East Park Energy

Applicant's Response to Deadline 4 and 5 Submissions – Other Interested Parties

Document Reference: EN010141/DR/8.70

August 2026

Drawing Title
**Indicative Vegetation Clearance
Sheet 1 of 5**

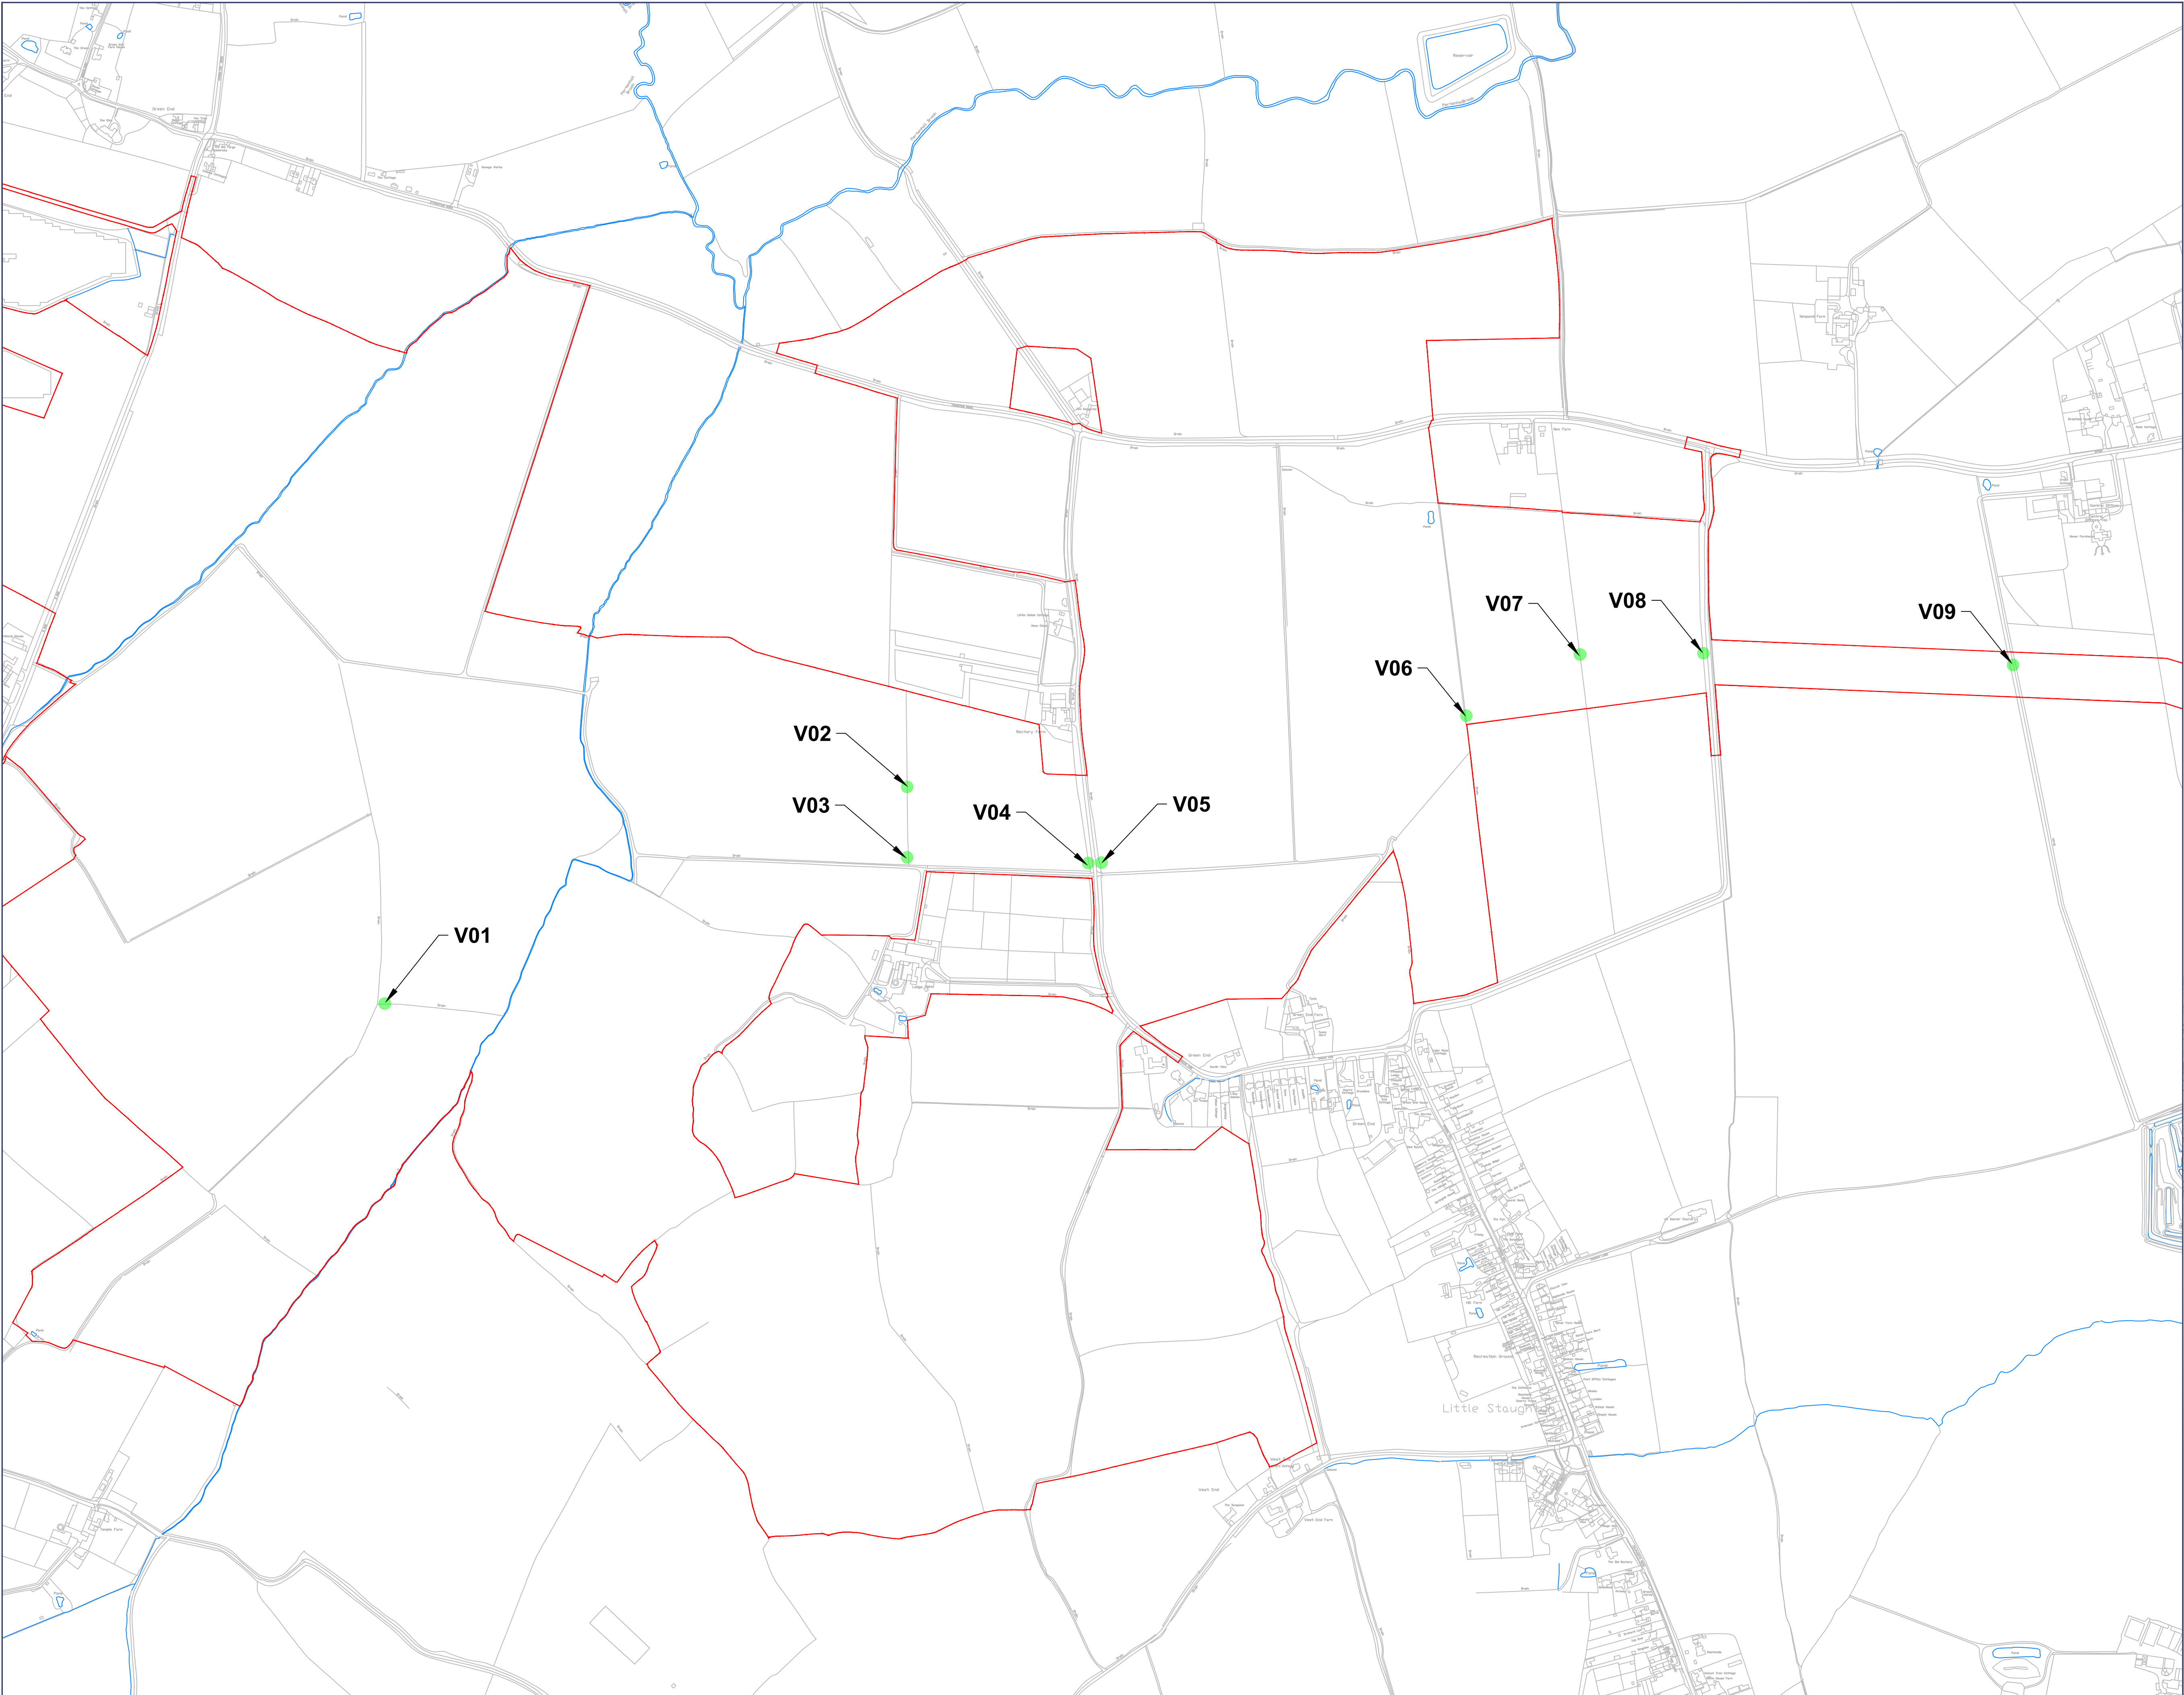
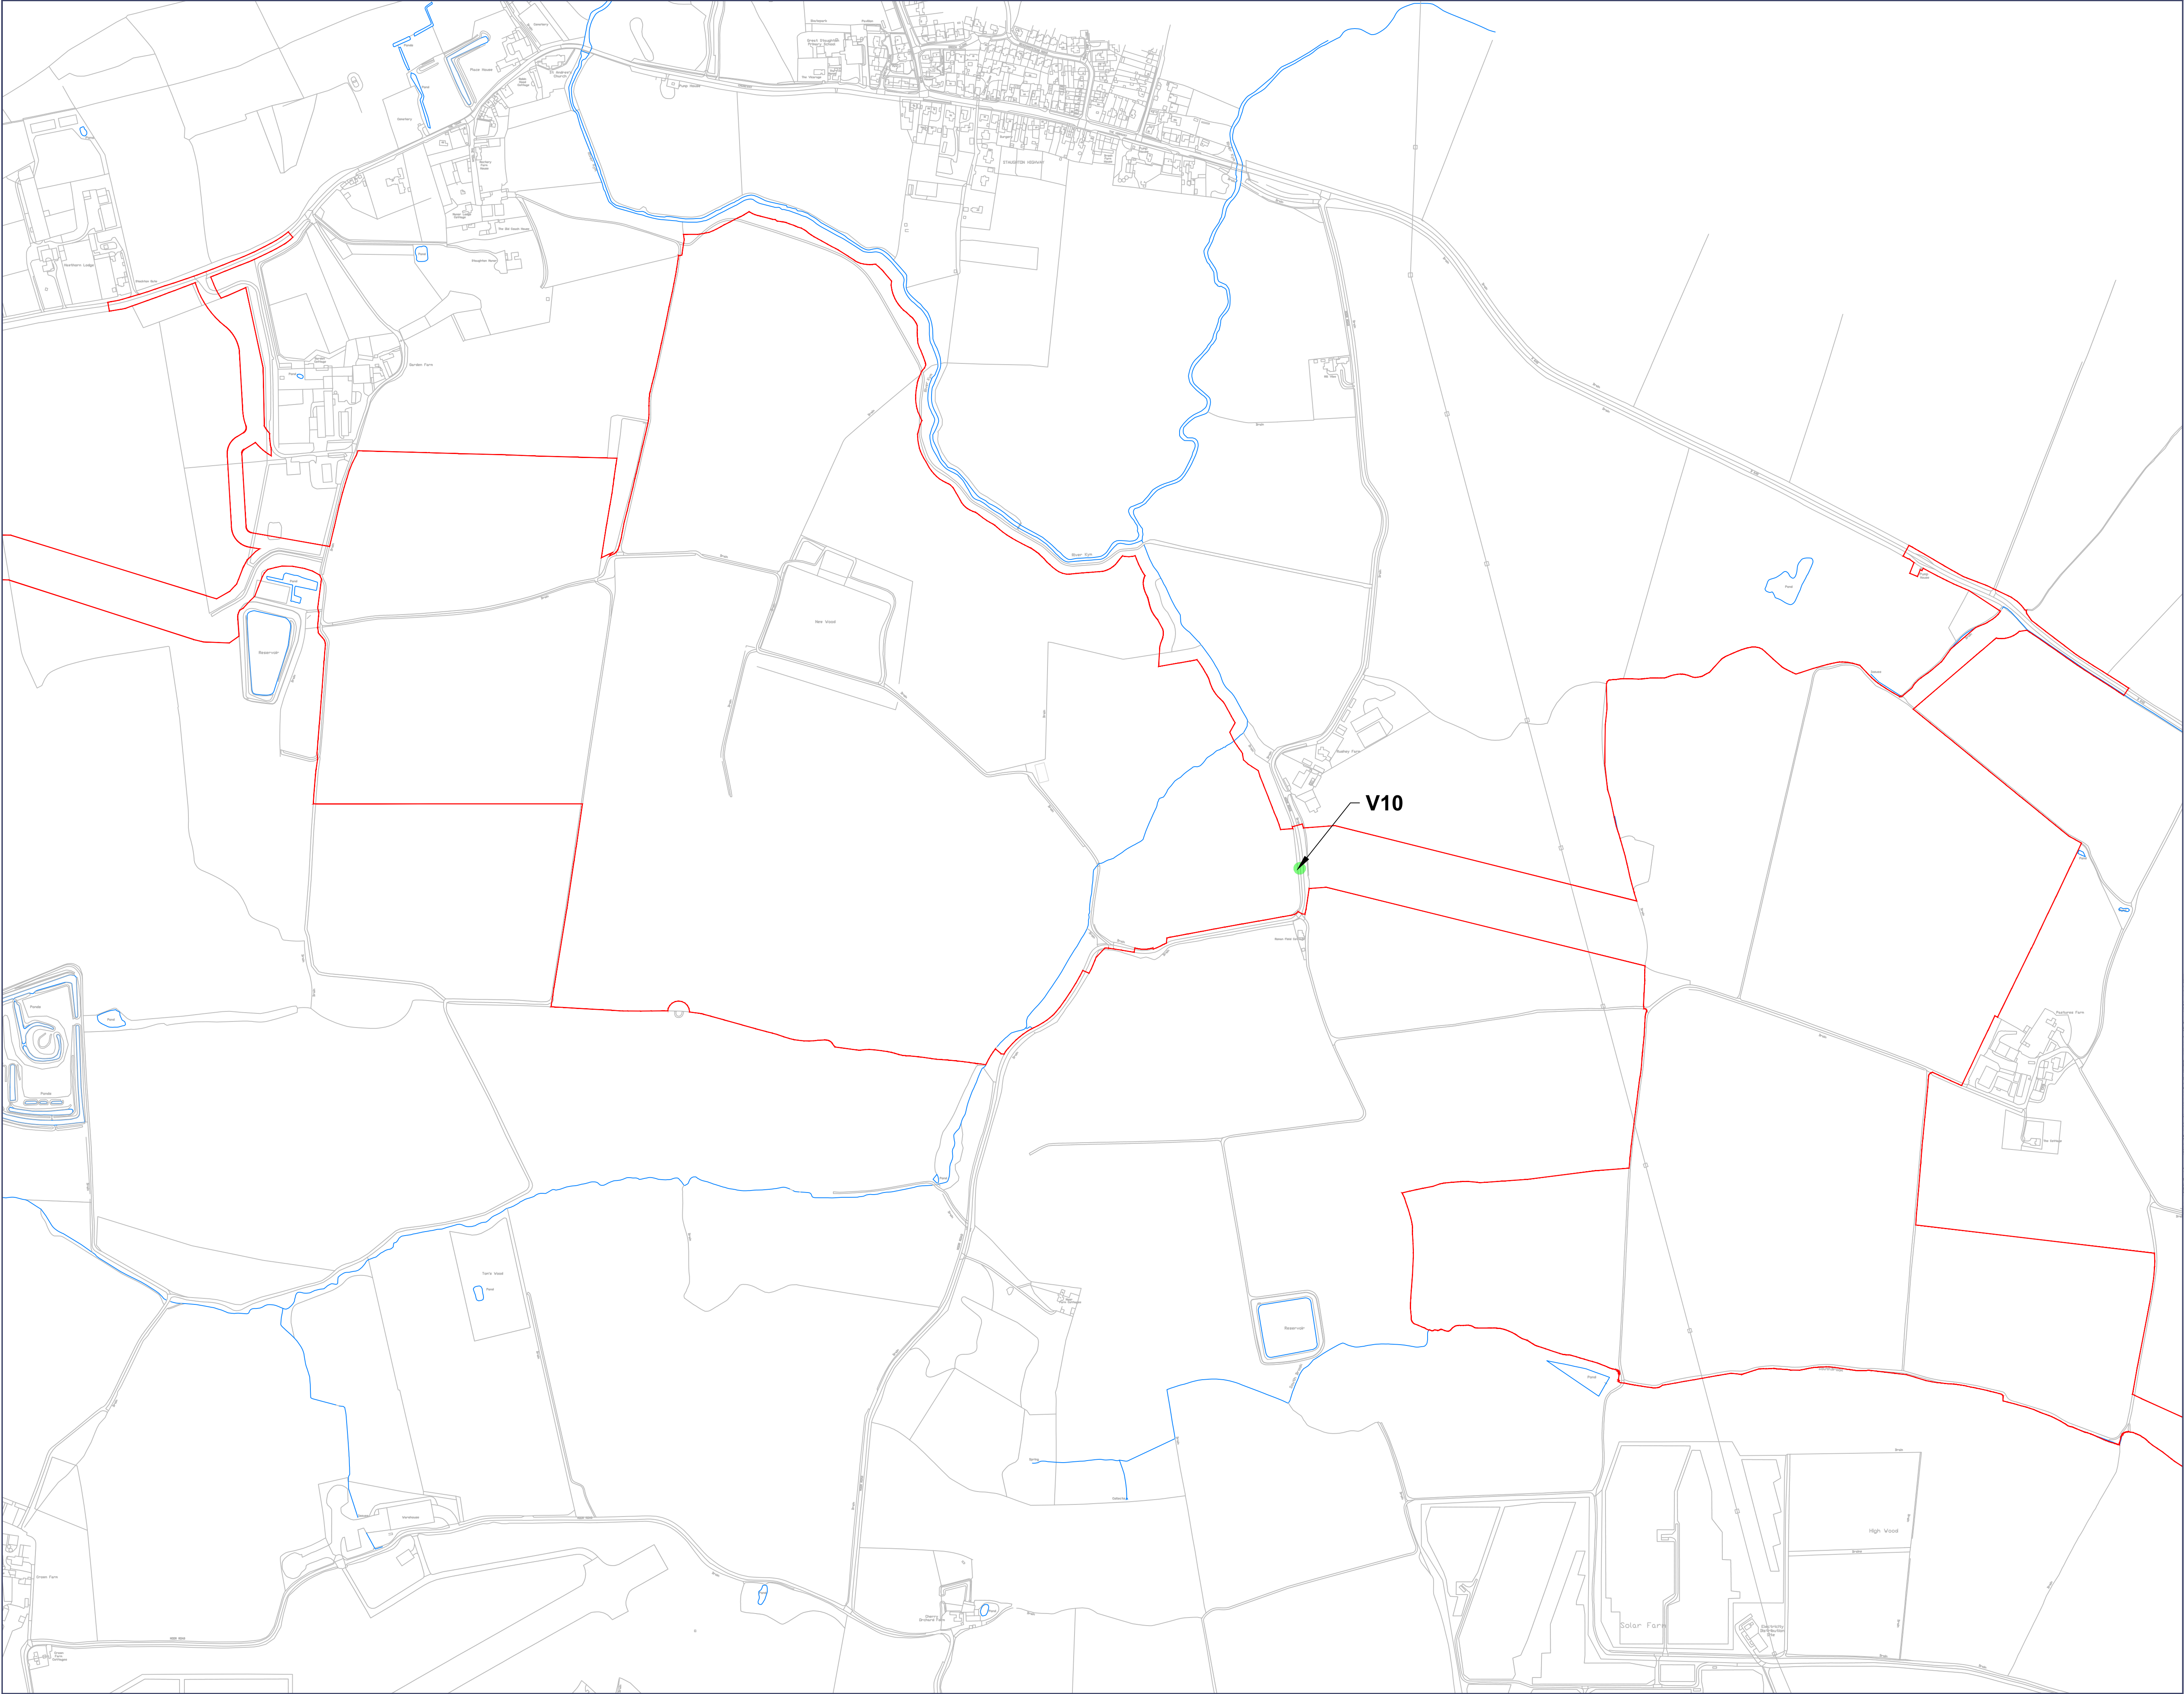
PM-D5-04	What damage will be done when putting all the access points in to get this construction completed, how big will the access points be and what level of hedge. Tree screening will be damaged for all site access points, also what limitation on signs that are likely to be there for 3 years will be put in place?	The oCTMP [REP4-095] includes a series of drawings, in Appendix D, showing the site access drawings. The required vegetation clearance is best shown on ES Vol 3 Figure 2-6 Indicative Vegetation Clearance [APP-126], supported by the description in Table 2-34 of ES Vol 1 Chapter 2

Our Ref.	Comment	Applicant Response
PM-D5-05	What level of hedge and tree removal is planned to achieve this development, where is the overall assessment of the impact to wildlife/villagers and visual appearance been made. What will happen to gaps within hedgerow is there are planting statement if removal is needed or damaged, rather than a sea of panels as far as the eye can see ? A timebound plan that happens at set points during construction not at the end of the project when it could get overlooked	[APP-038]. A Tree Impacts Plan is also provided as part of ES Vol 2 Appendix 2-2 Arboricultural Impact Assessment [APP-056]. Mitigation measures to control impacts such as signage at access points are set out in the oCTMP [REP4-095].
